Re: Submission on the Stage 1 EIS for the Northern Beaches Hospital (SSI 5982)

Stage 1 Environmental Impact Assessment State Significant Infrastructure – Northern Beaches Hospital (SSI 5982)

**Figure 1: Aerial photograph showing location of subject land**

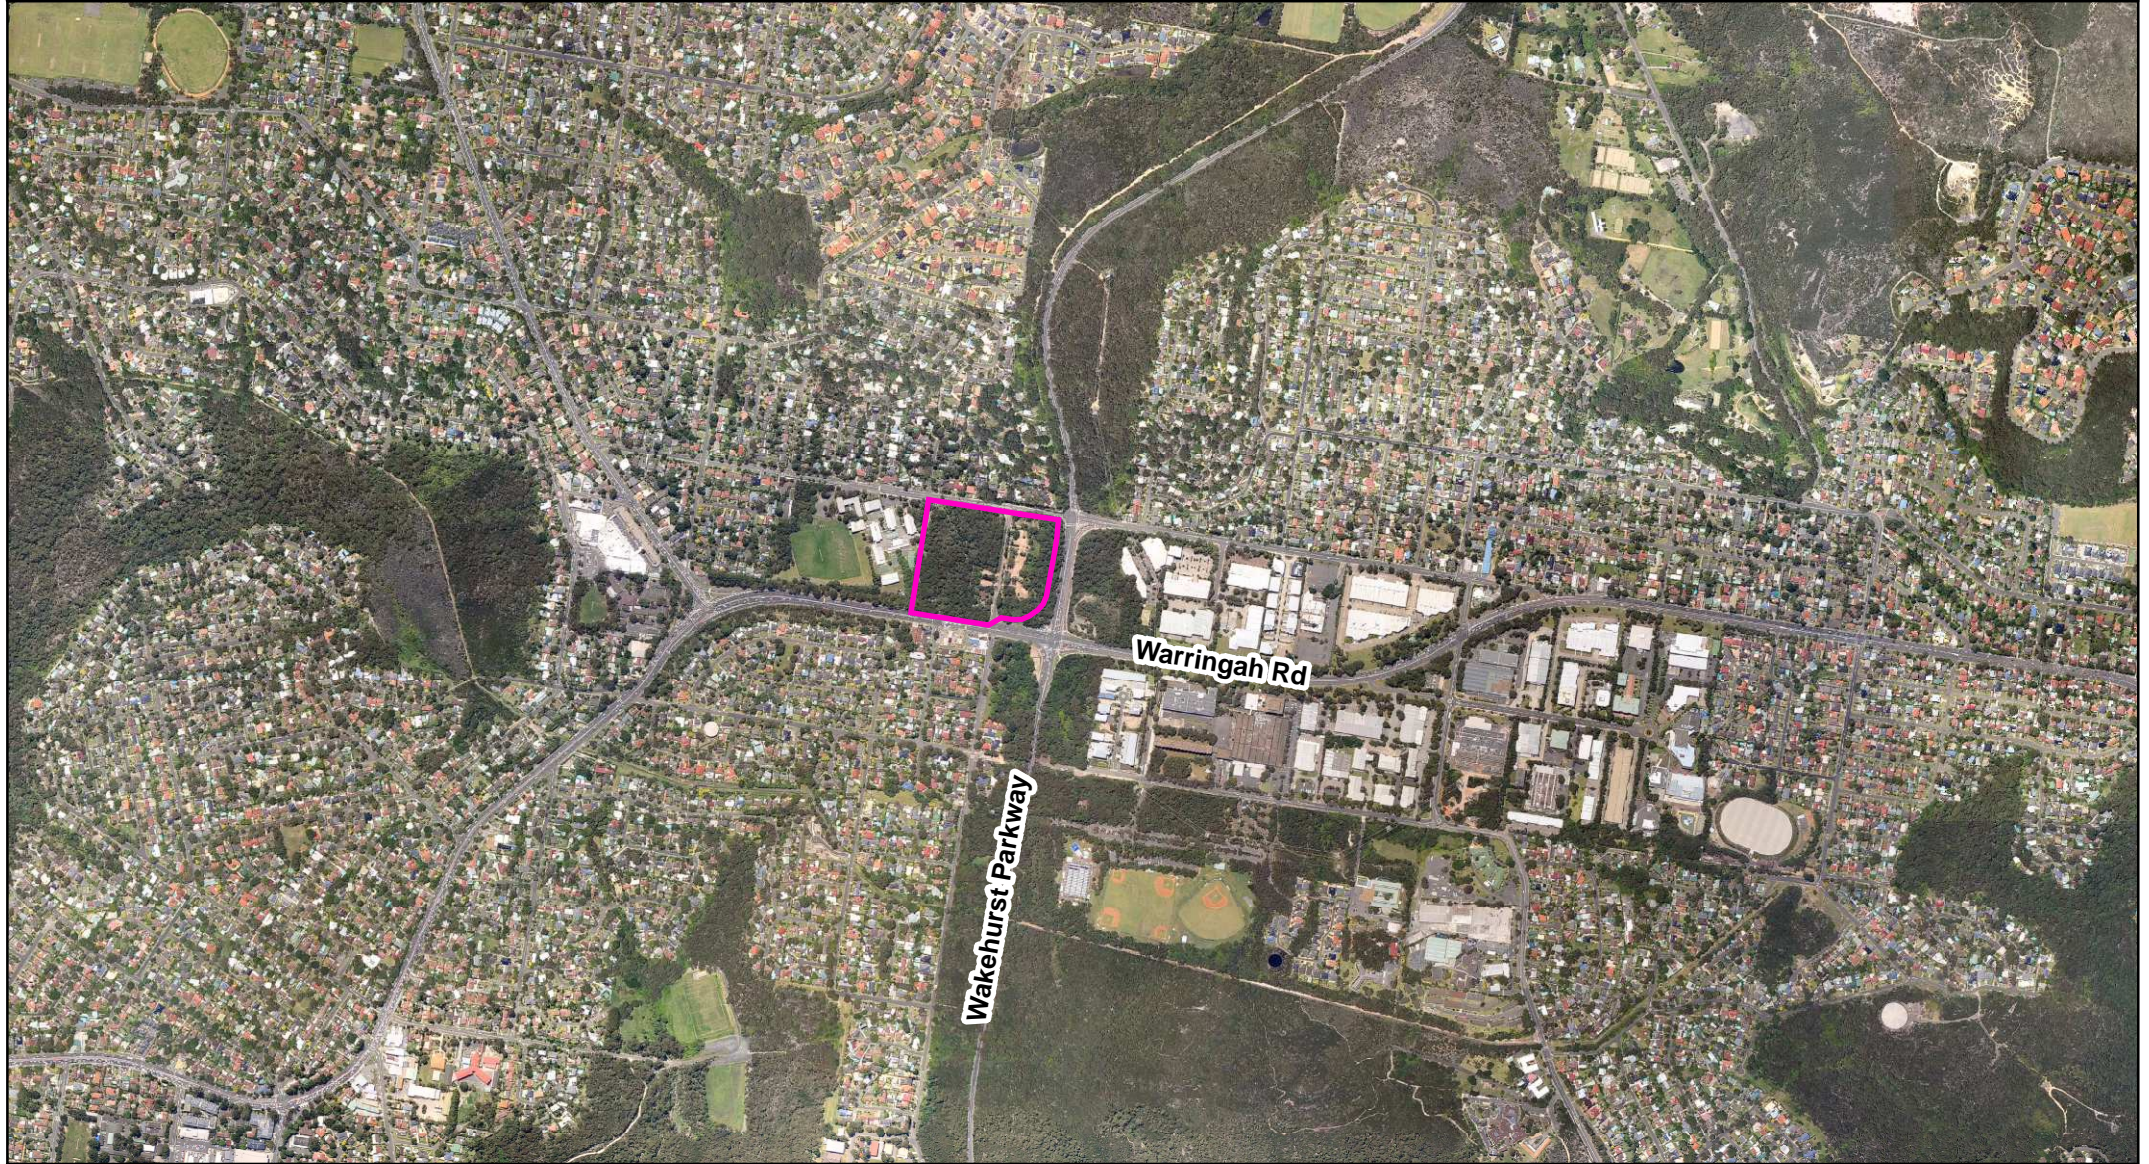
Issue - The EIS reports are considered inconsistent in relation to statements that vegetation in Blinking Light Reserve will largely be retained, with the exception of thinning of understorey vegetation (Biodiversity Offset Strategy, SMEC, 2011). This appears to be inconsistent with the Bushfire Constraints Advice (EcoLogical Australia, 2011) which suggests that APZs between 70 and 100m will be required.

It is likely that the retained vegetation in Blinking Light Reserve would need to be thinned so as to be consistent with an 'Inner Protection Zone' that is associated with special fire protection purposes. This would require substantial modification of any vegetation to be retained on the site including the canopy, and is thus inconsistent with the Biodiversity Offset Strategy.

Recommendation – amend reports to ensure consistency between the reports. Impacts should then be mitigated and offset accordingly.

Figure 5: Indicative Proposed Site Vehicle Access Arrangements (Note: Indicative Site Layout)

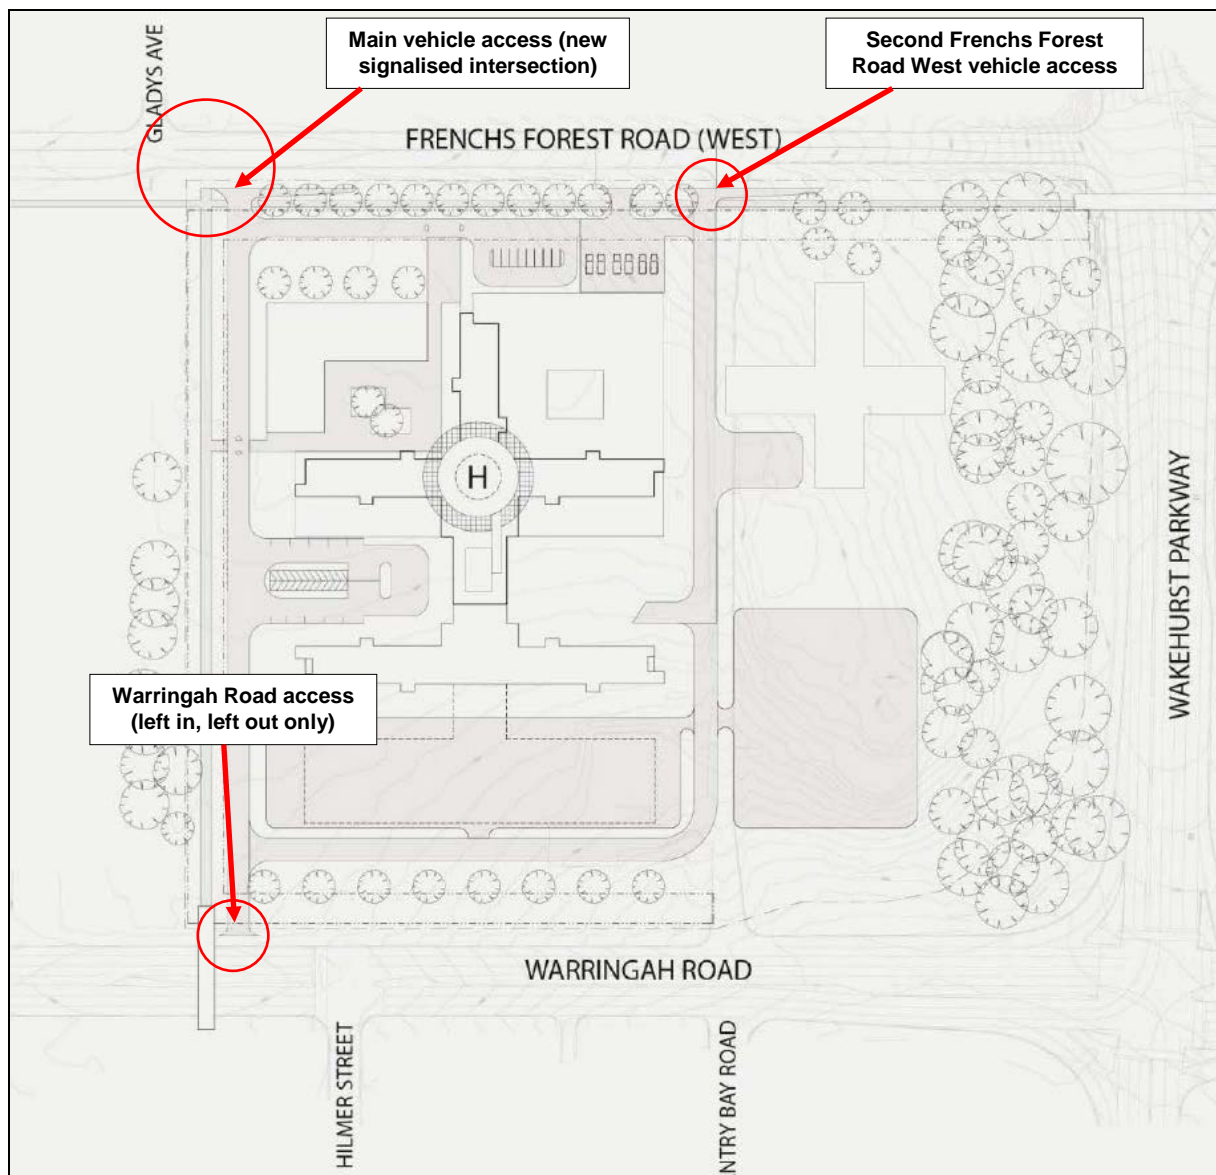
Council is concerned that the main access to the hospital is proposed via Frenchs Forest Road West, particularly in the absence of any road infrastructure improvements. It appears that due to the lower traffic flows between Frenchs Forest Road West and Warringah Road it has been chosen to carry the bulk of the hospital traffic. Traffic exiting the site will still need to negotiate the badly congested intersections of Warringah Road with Wakehurst Parkway and Forest Way.

Council's previous suggestion that the main entry to the site utilise the existing traffic lights at Warringah Road and Hilmer Street has not been taken. Frenchs Forest Road West should form the secondary access to the hospital. If Frenchs Forest Road West remains the main access to the Hospital site, there will be significant traffic increases on the Council roads Frenchs Forest Roads West and East, as well as Allambie Road. Making provision for increased traffic on these roads will require a detailed traffic impact assessment and identification of road and intersection improvements, along with consultation with the local community whom for many years have been subject to increased traffic flow through the residential areas as a result of the congested intersections highlighted above.

Figure 8: Proposed service diversion works zones (outlined in blue) and APZs (hashed in yellow)

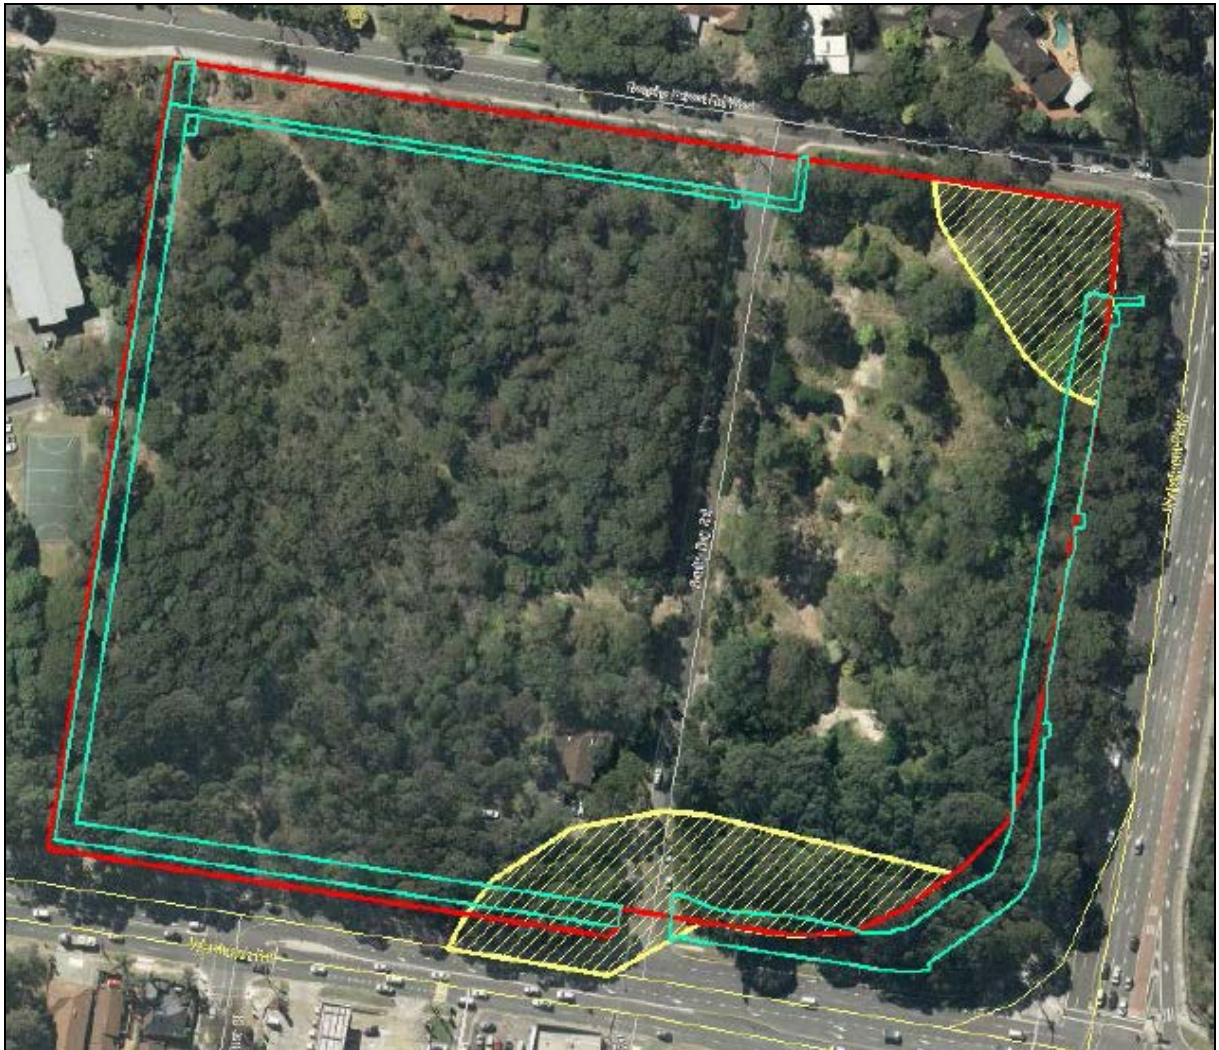
Issue: The Biobanking credit calculations have not accounted for the modification of the Duffys Forest Endangered Ecological Community within Blinking Light Reserve. This area has been omitted from the Biobanking Assessment Report 2013 (James, 2013). As stated above, this vegetation will be substantially impacted by proposed bushfire protection activities.

Recommendation: Offset requirements should be based on the full quantum for vegetation to be impacted.

Figure 9: Indicative NBH Envelope and Site Layout Reference Design – north western view

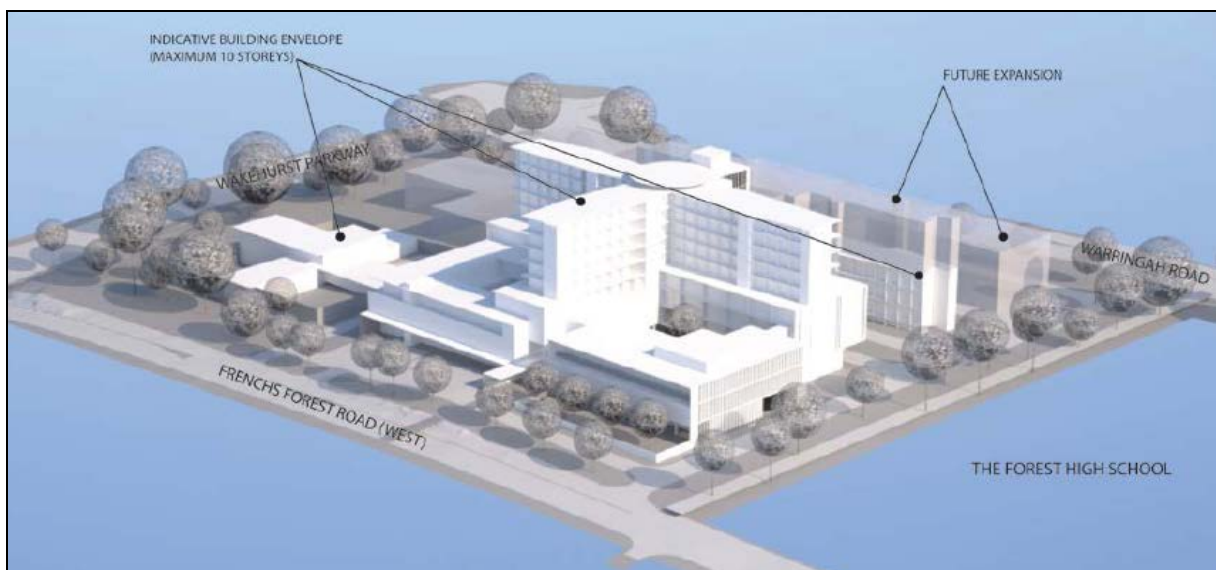
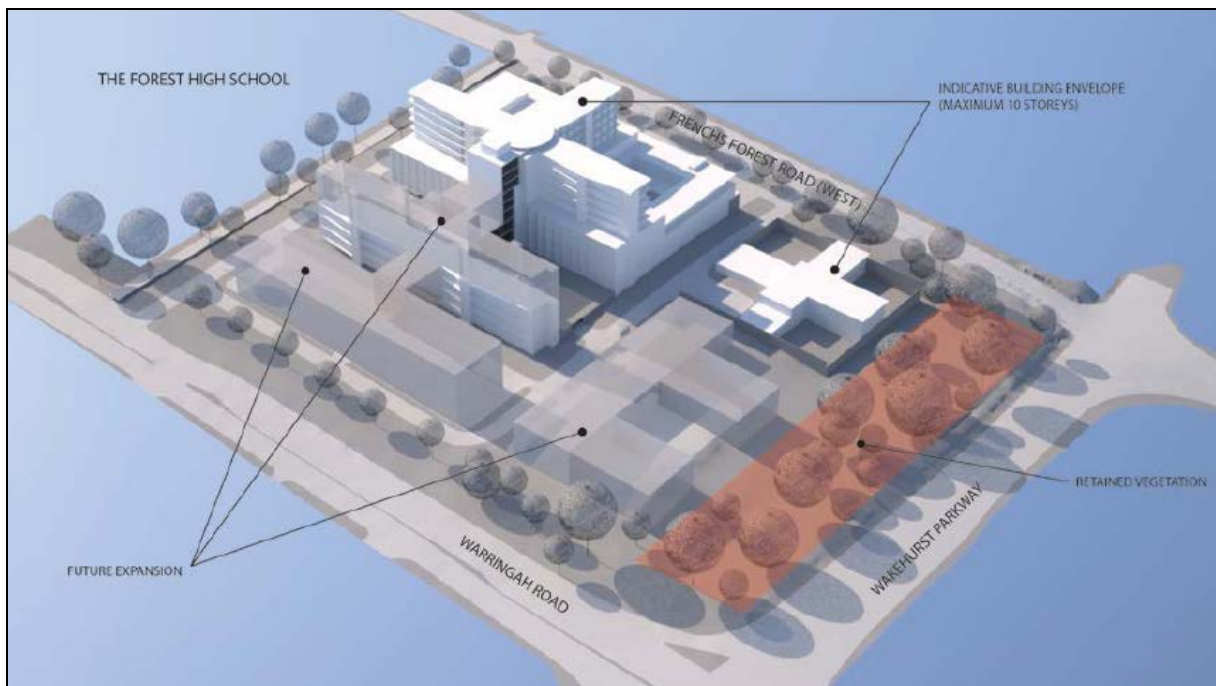
The concept of setting back the building, particularly from Frenchs Forest Road West is agreed with as this reduces the building bulk and massing on that part of the site immediately adjoining existing low density residential development. It is agreed that concentrating the hospital facility into a 6 – 10 storey building may be an appropriate response, as this could result in a more efficient facility, with acceptable and appropriate setbacks and additional on-site open space and pedestrian linkages.

However, in discussing the built form design, the EIS refers to proposed height limits for surrounding development, from the Cox Richardson (2010) State Significant Site (SSS) Study, which proposed a height limit of 4 storeys (13 metres) for medium density residential development to the north, south and west of the site.

These comments in the EIS are misleading and based on a redundant study for a previous State Significant Site proposal, which was abandoned in December 2011.

The residential land in the vicinity of the hospital site is currently not zoned for medium density housing and does not have a 13 metre height limit. The EIS (page 44) states that "...buildings at the site's perimeter should be in scale with proposed medium density residential height limit of 13 metres". This statement is incorrect and should be deleted from

the EIS along with any other discussion based on relating the concept plan to the recommendations of the Cox Richardson SSS Study.

The concept plan should recognise that it will be located opposite existing low density residential development and the scale and massing should take this into account.
